East Yorkshire Solar Farm Nationally Significant Infrastructure
Project

Registration Comments

March 2024

PROJECT
East Yorkshire Solar Farm

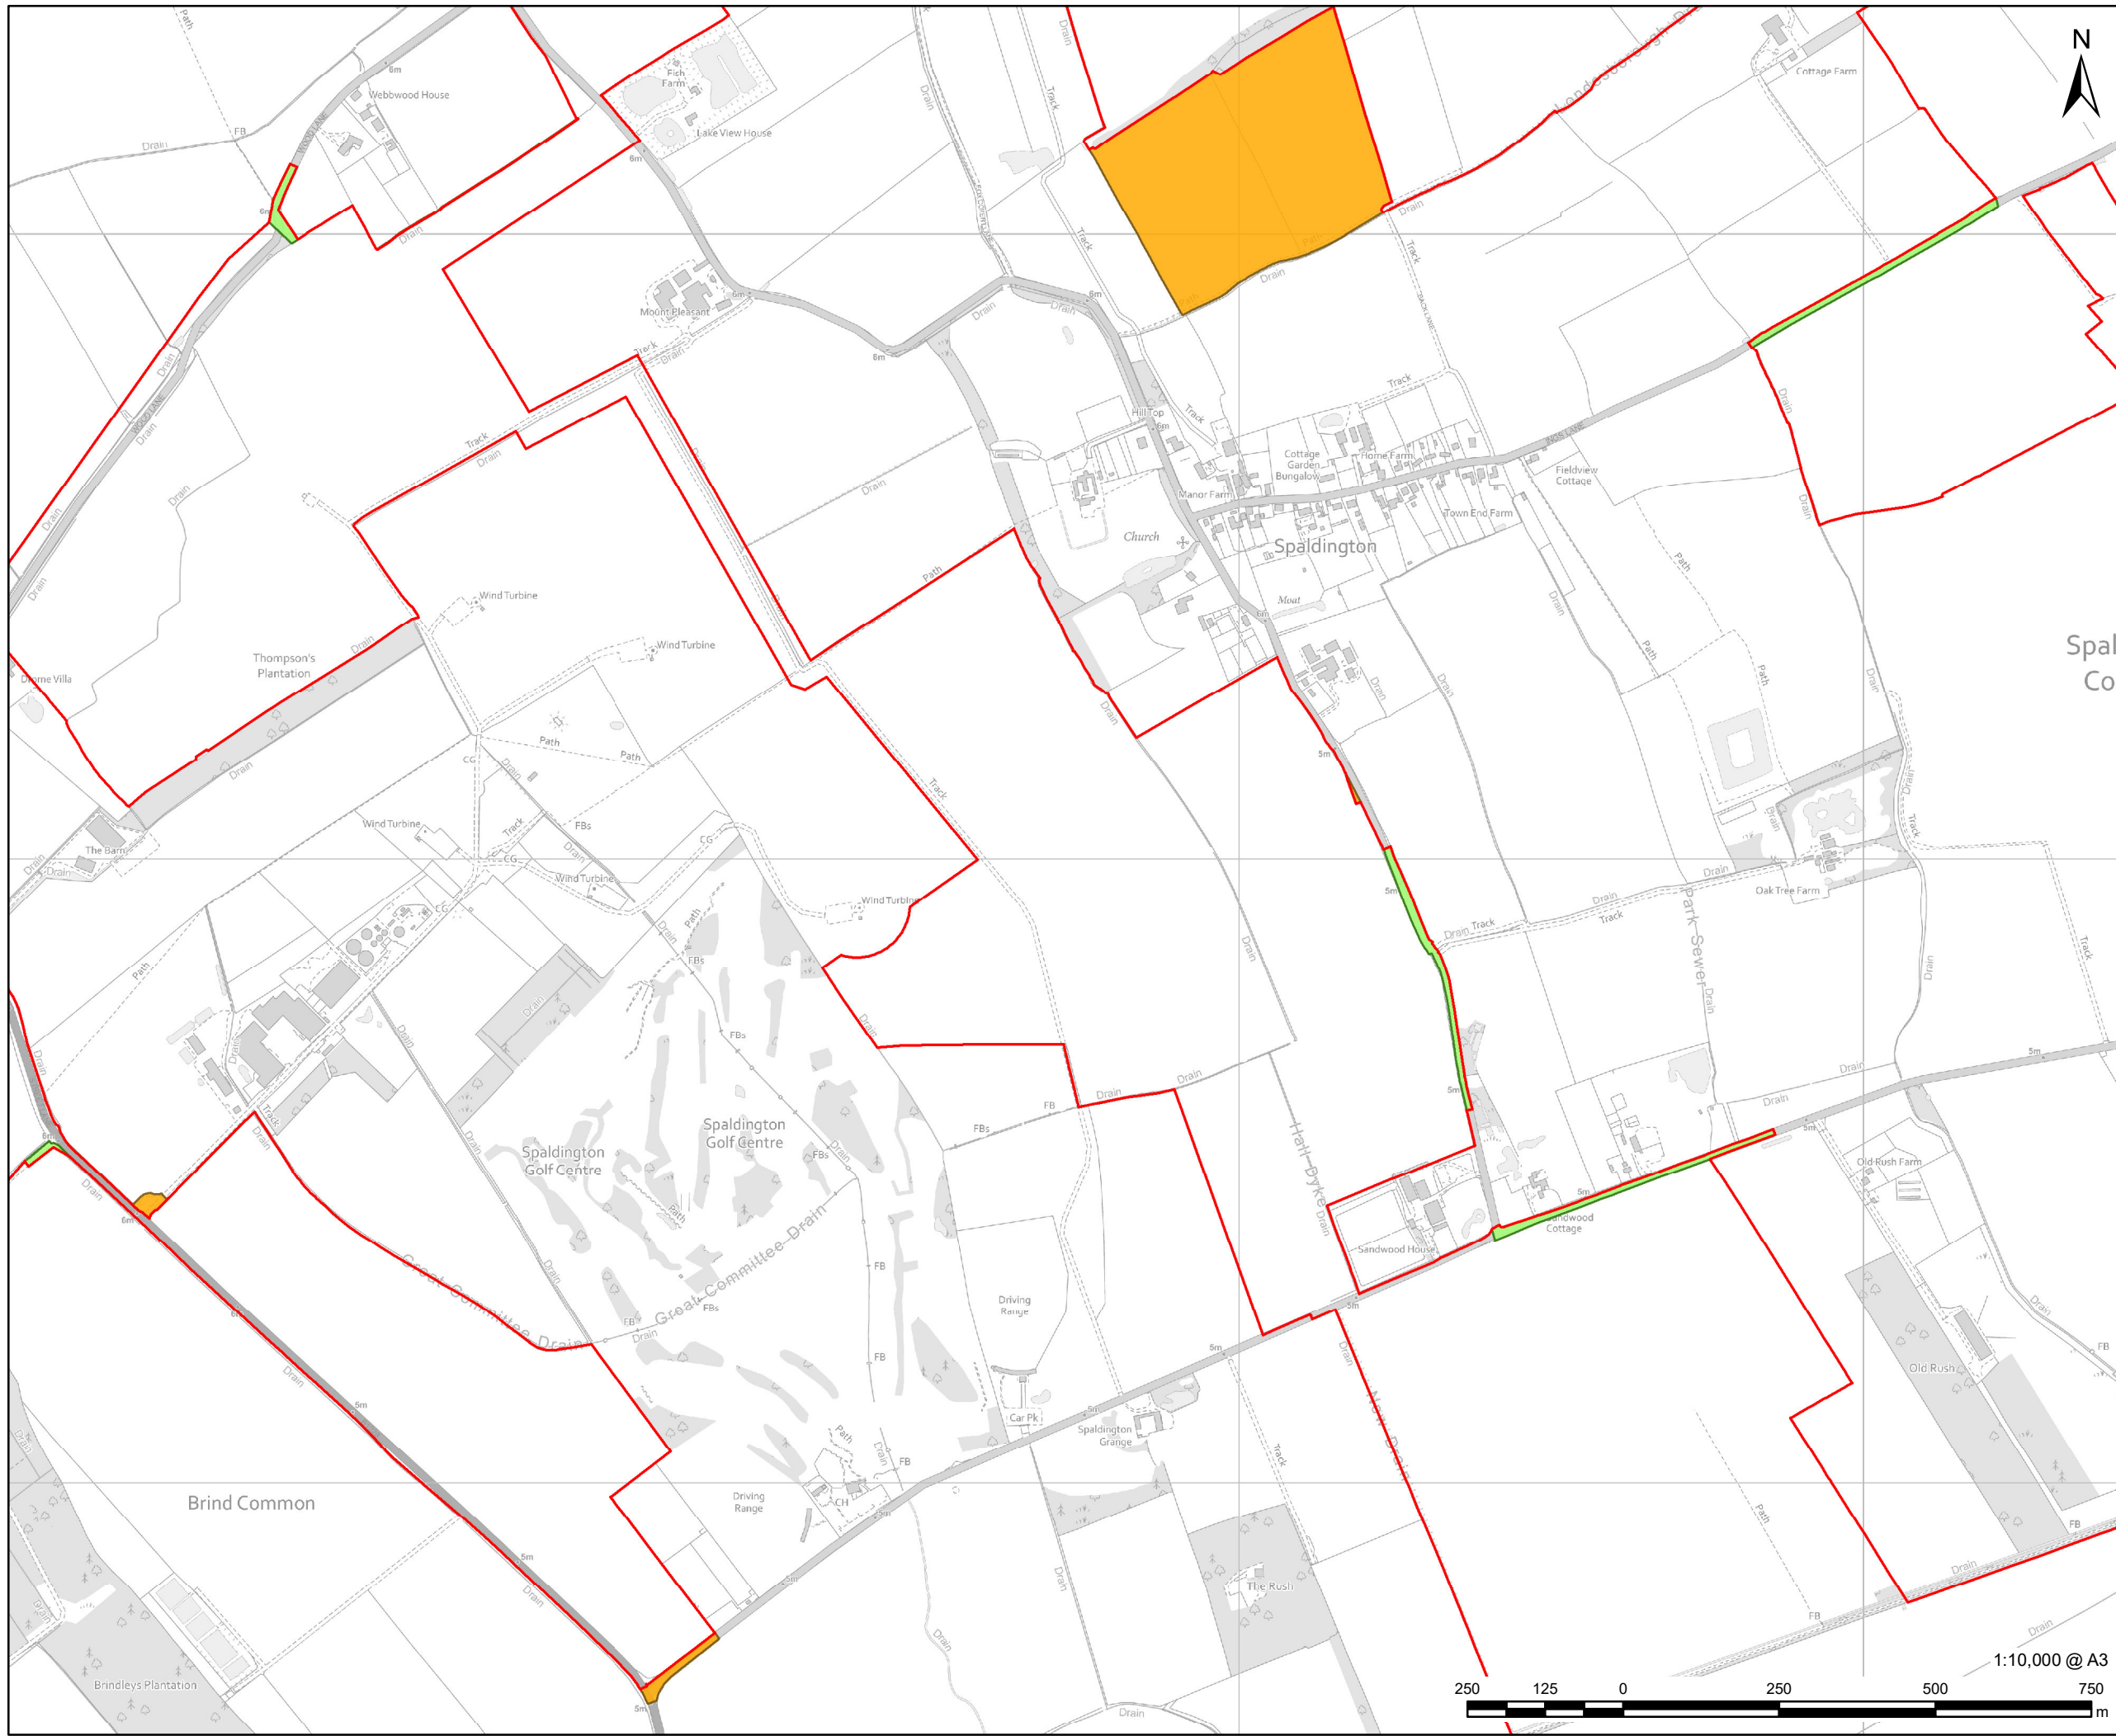
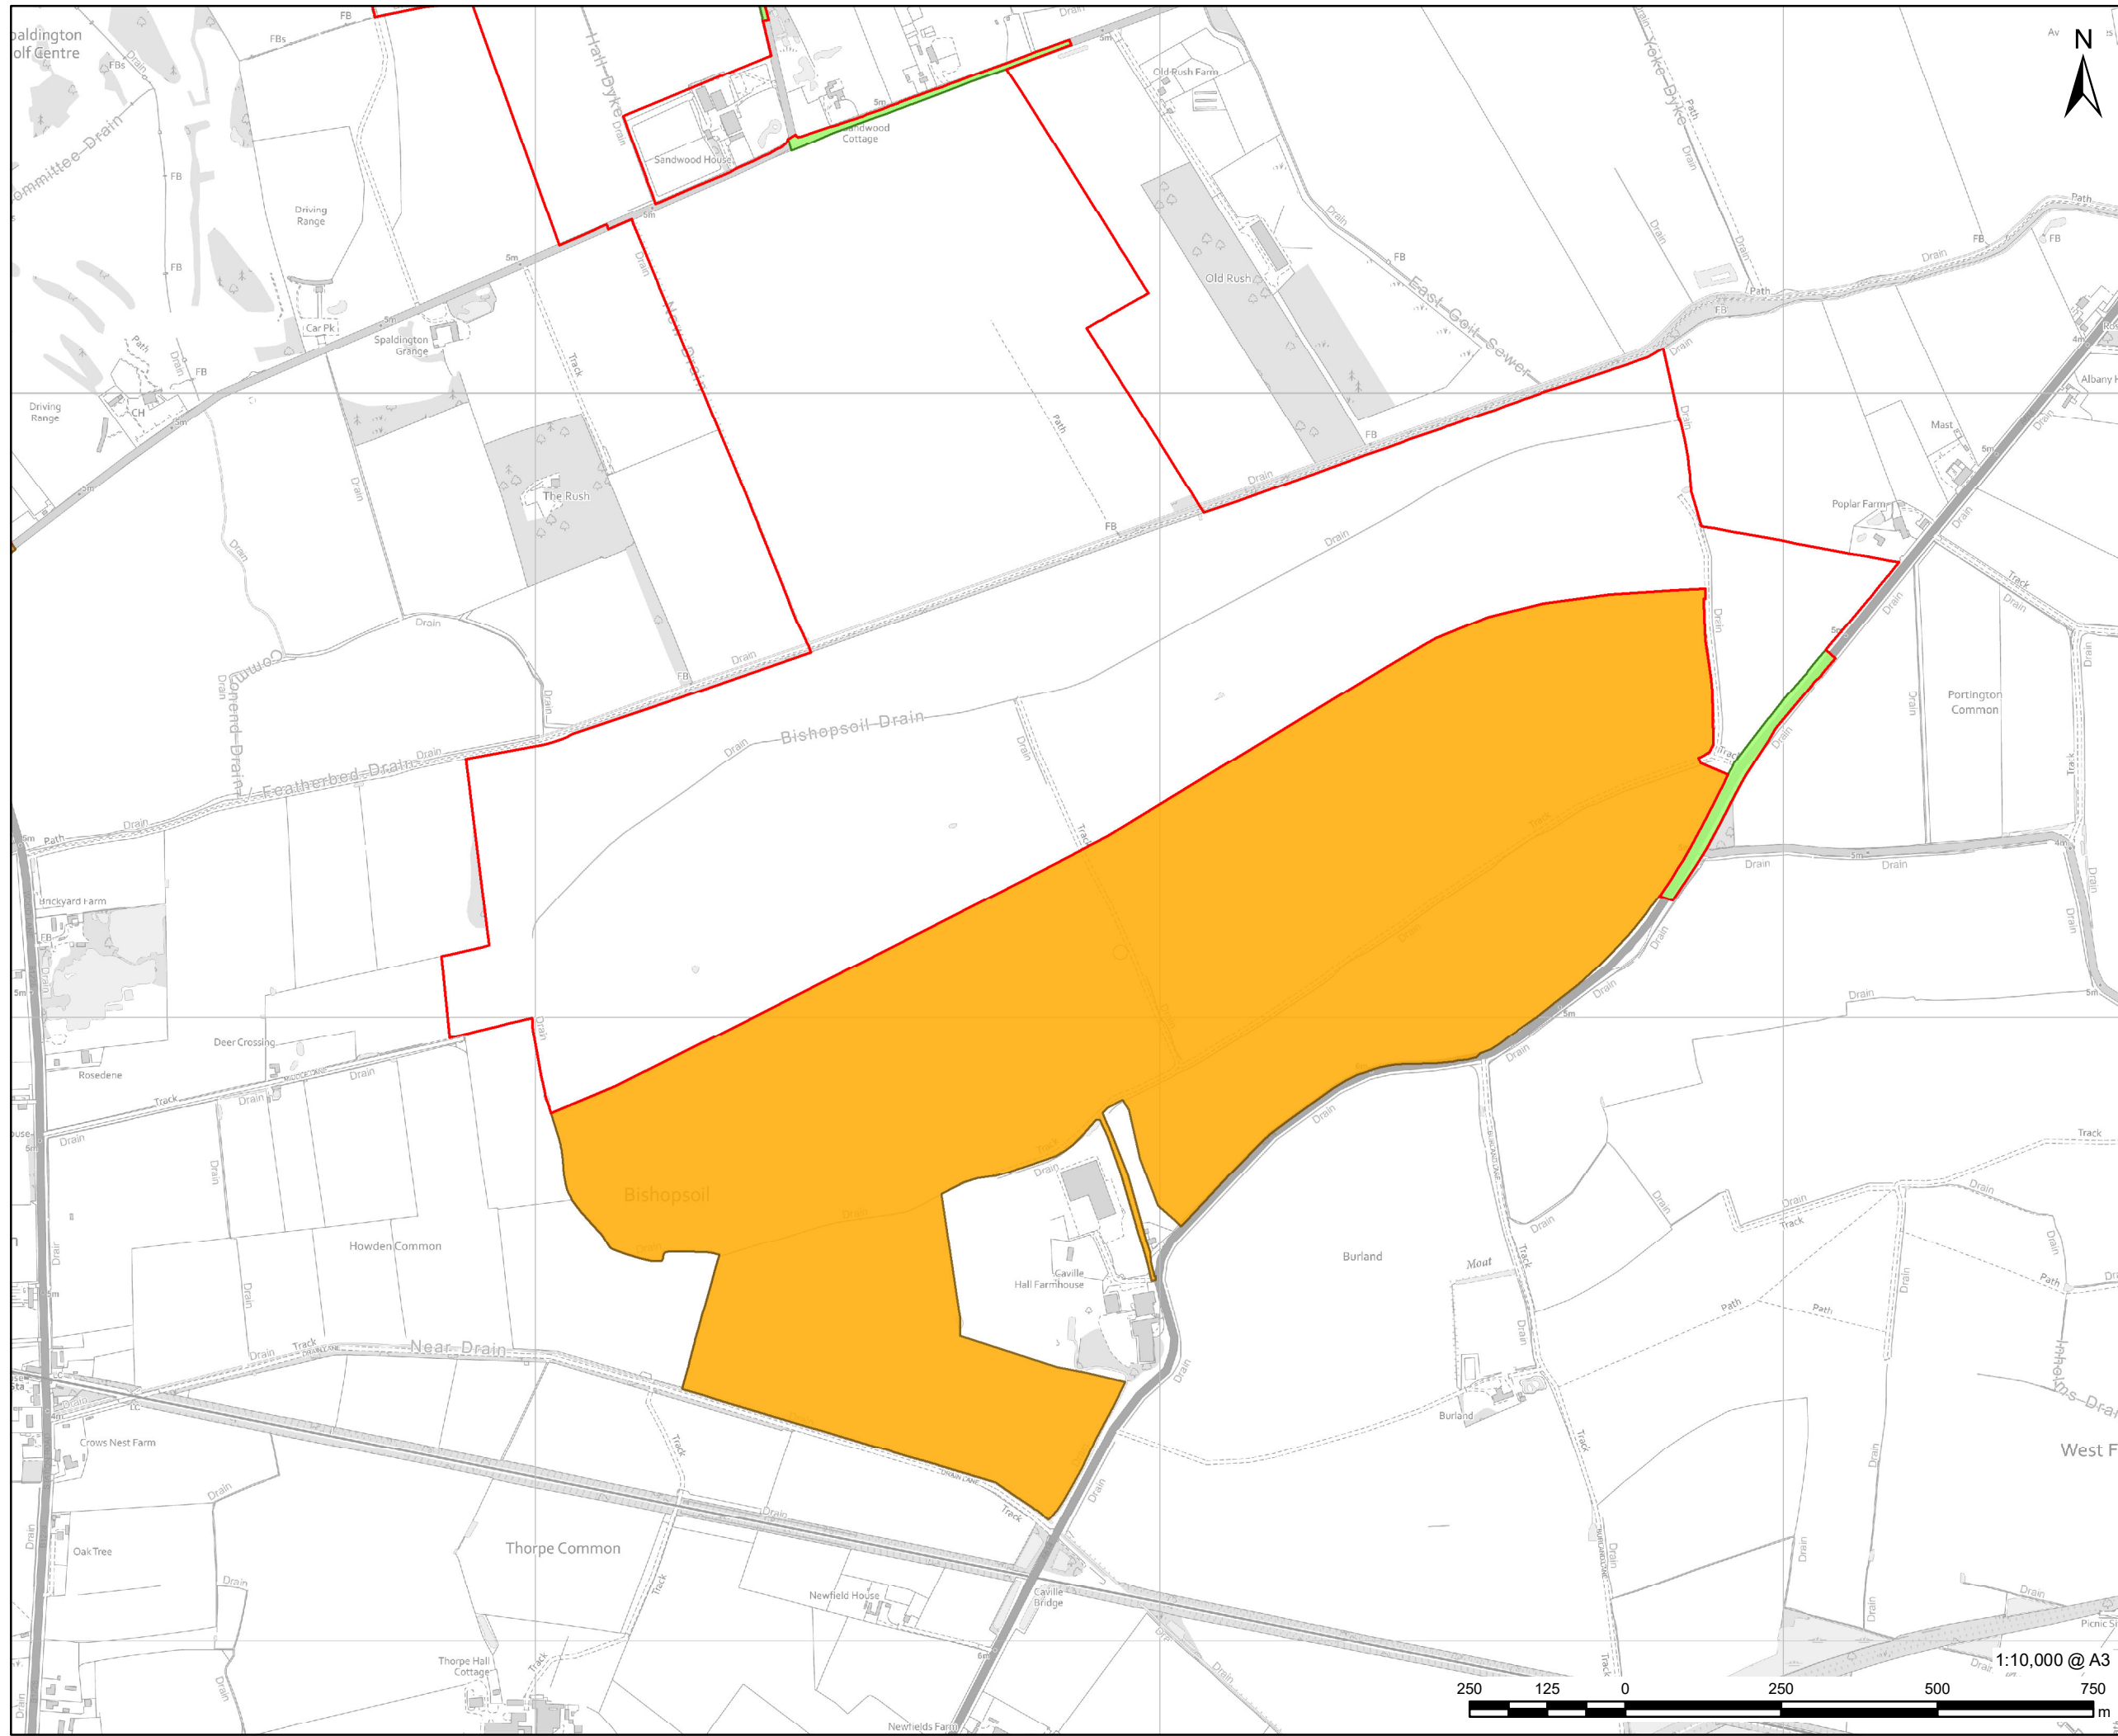
- 2.4. Contrary to this guidance it appears that the applicant has not addressed site-specific issues in relation to our client's property, nor indeed wider issues in relation to impacts on landscape and public rights of way. This is noted from a comparison of the early engagement illustrative plans and the submitted proposal (see **Appendix 1** of this representation). Despite our client writing to the applicant on numerous occasions to raise their concerns, the layout surrounding our client's property has not changed substantially. The same planting scheme appears to have been retained at the north of area 2f and the volume of panels increased in area 2e.
